# The Parish Councils of Assington, Bures St Mary, Leavenheath, Little Cornard, Polstead & Stoke by Nayland

## Interim combined response to Examining Authority's First Written Questions (ExQ1)

DEDHAM VALE EAST SEALING END COMPOUND:
 PLAN VIEW
 SCALE 1:200

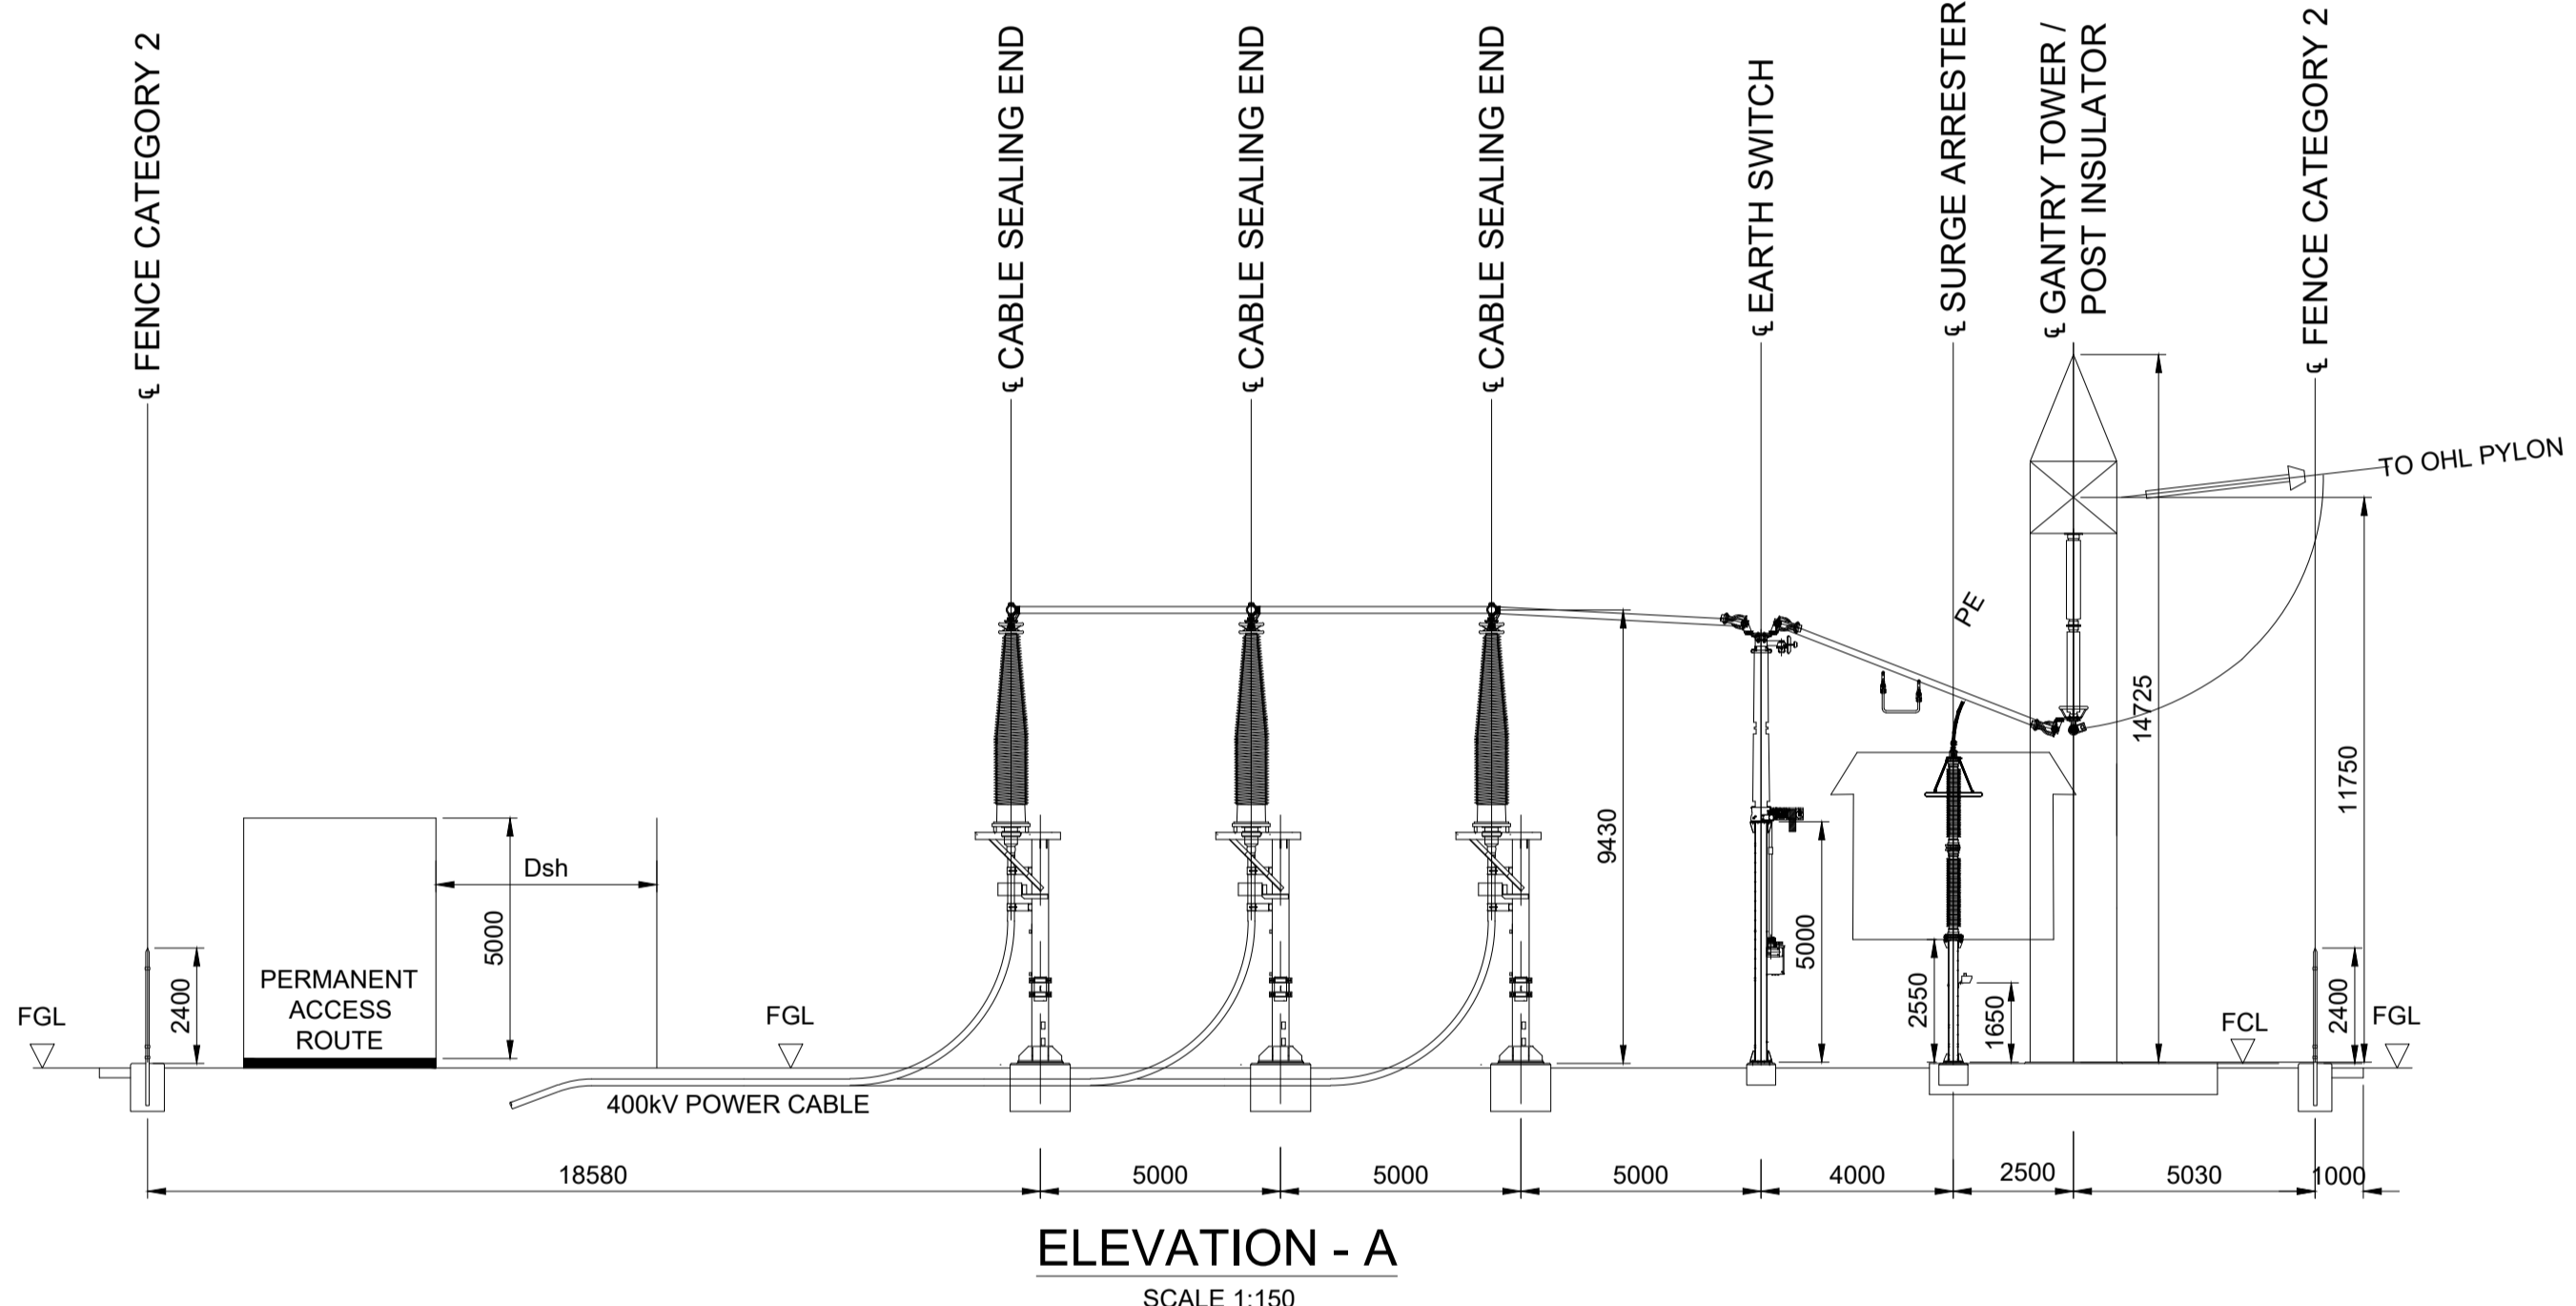
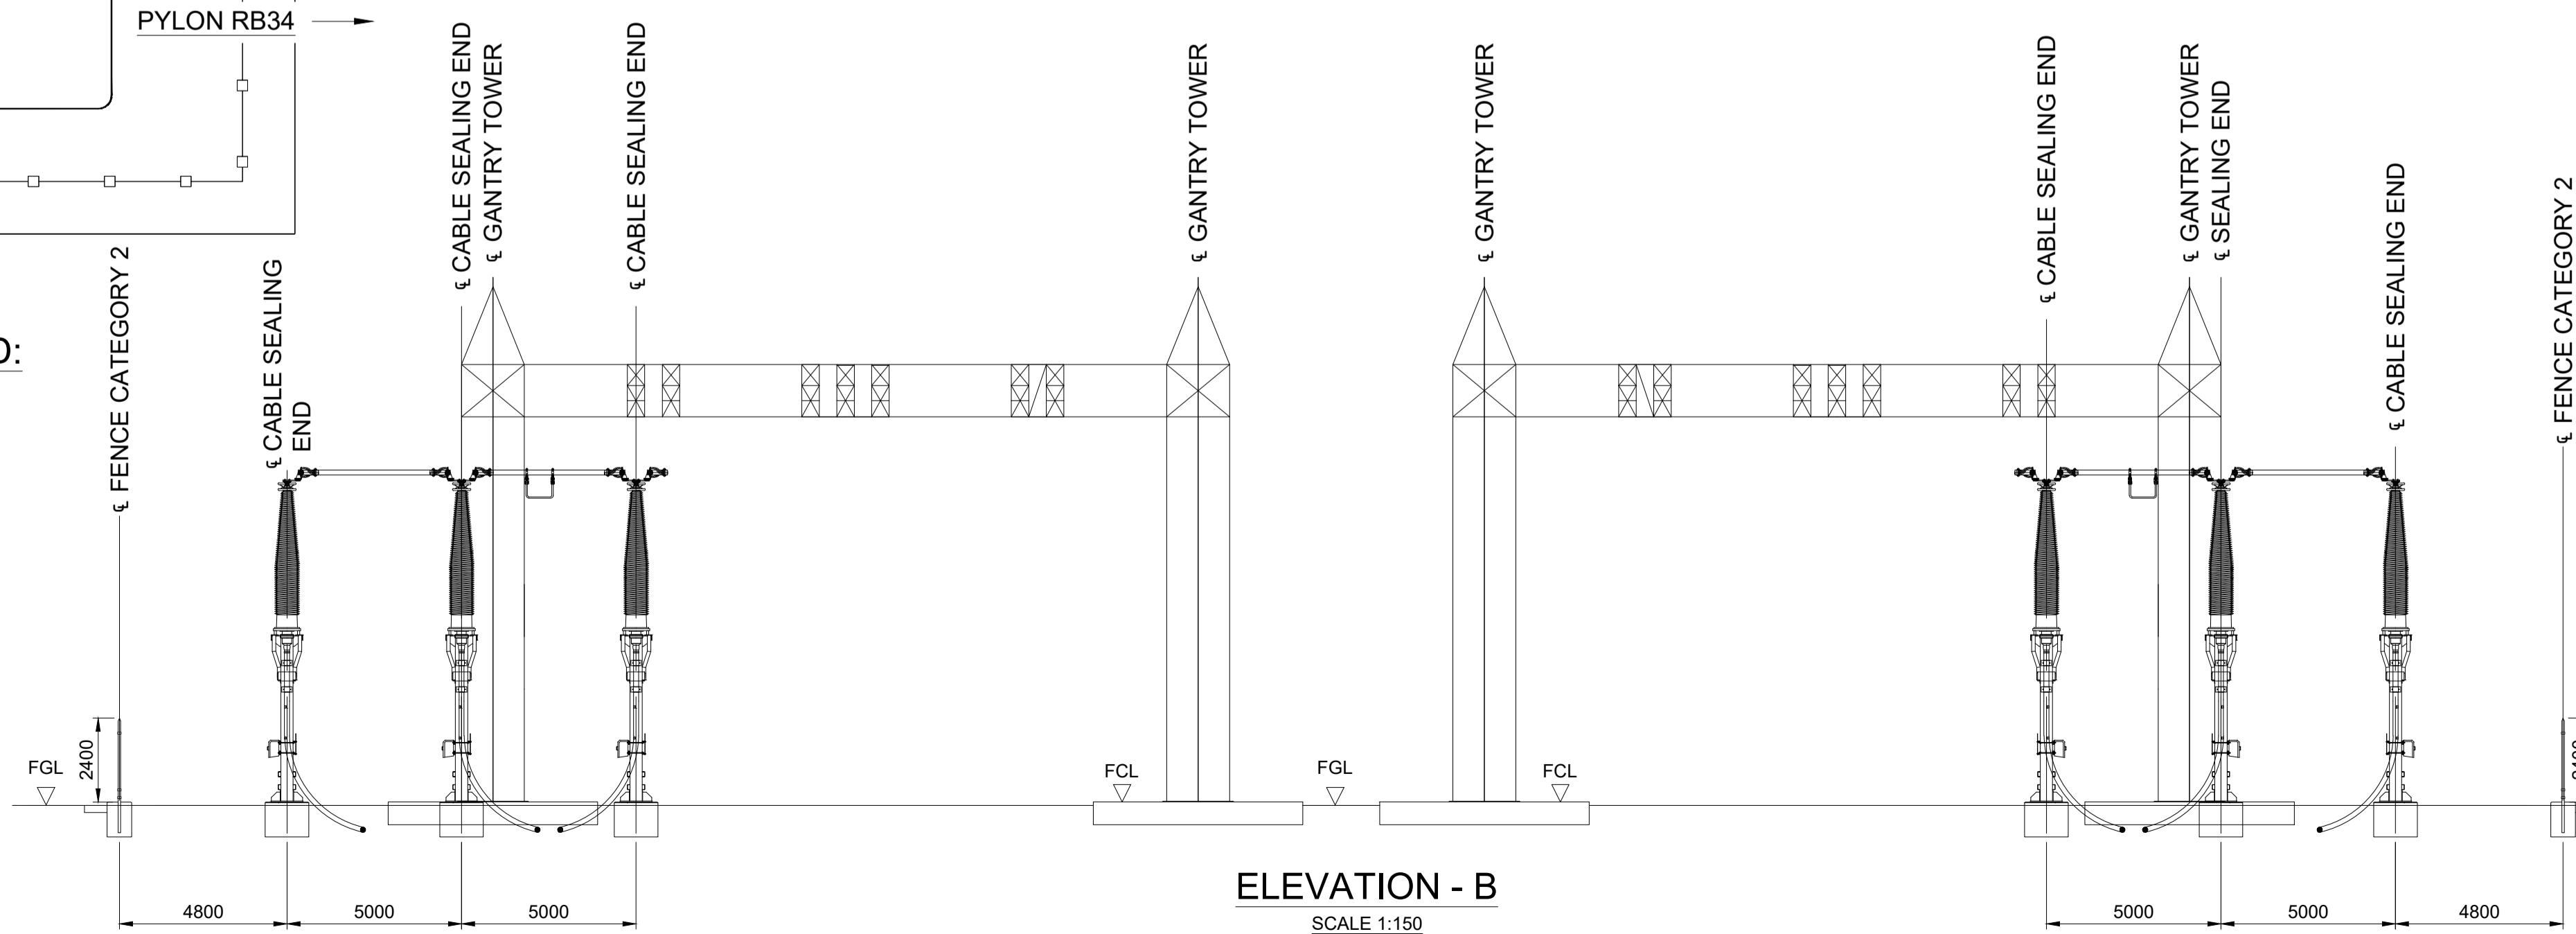
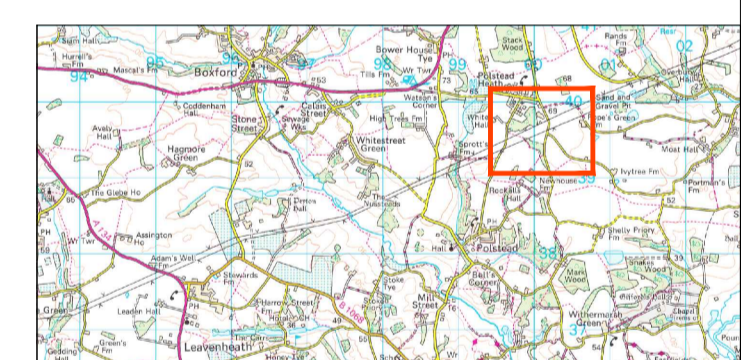
- 3.1 The area covered by the parish councils includes three Cable Sealing End compounds: Dedham Vale East, Dedham Vale West and Stour Valley East.
- 3.2 The proposed designs for the CSECs (APP-023-025) show compounds 70m x 45m surrounded by fences 2.4m high and containing gantries 14.7m high.

- 3.3 In form, material and design, the CSECs are significant industrial installations, and their presence immediately adjacent to the edge of the AONB will inevitably affect the AONB's setting, principally but not exclusively through the significant visual effects of the CSECs and their permanent access roads. To mitigate this harm, and given that planting can only have a very limited impact, CSECs should be sited sufficiently far outside the boundary of the AONB to allow them to be screened out by landscape.

- 4.1 It is our unanimous view that the landscape and visual impact of the proposed Dedham Vale East CSEC site is sufficiently detrimental to the proximity and setting of the AONB that it should be relocated. We note the identical submissions made by Sally Ann Westwood (REP2-065), *et alia* to relocate the CSEC

- 4.4 Although no specific photos have been provided by the applicant of the CSEC when viewed from Millwood Road, the general views illustrated by the DV East CSEC photomontages provided by the applicant (APP-103 Views D.06 §28 & D.07 §30), the applicant's proposed site is exposed and highly visible, close to the AONB boundary and would have a profound impact on the landscape. The location of the CSEC is 53m to the west of Millwood Road at its closest point and linked to it by a permanent service road. It is about 150m from Oakdene, the nearest dwelling, to the North, approximately 170m from the footpath linking Heath Road and Millwood Road and 300m from Heath Road at its closest point.
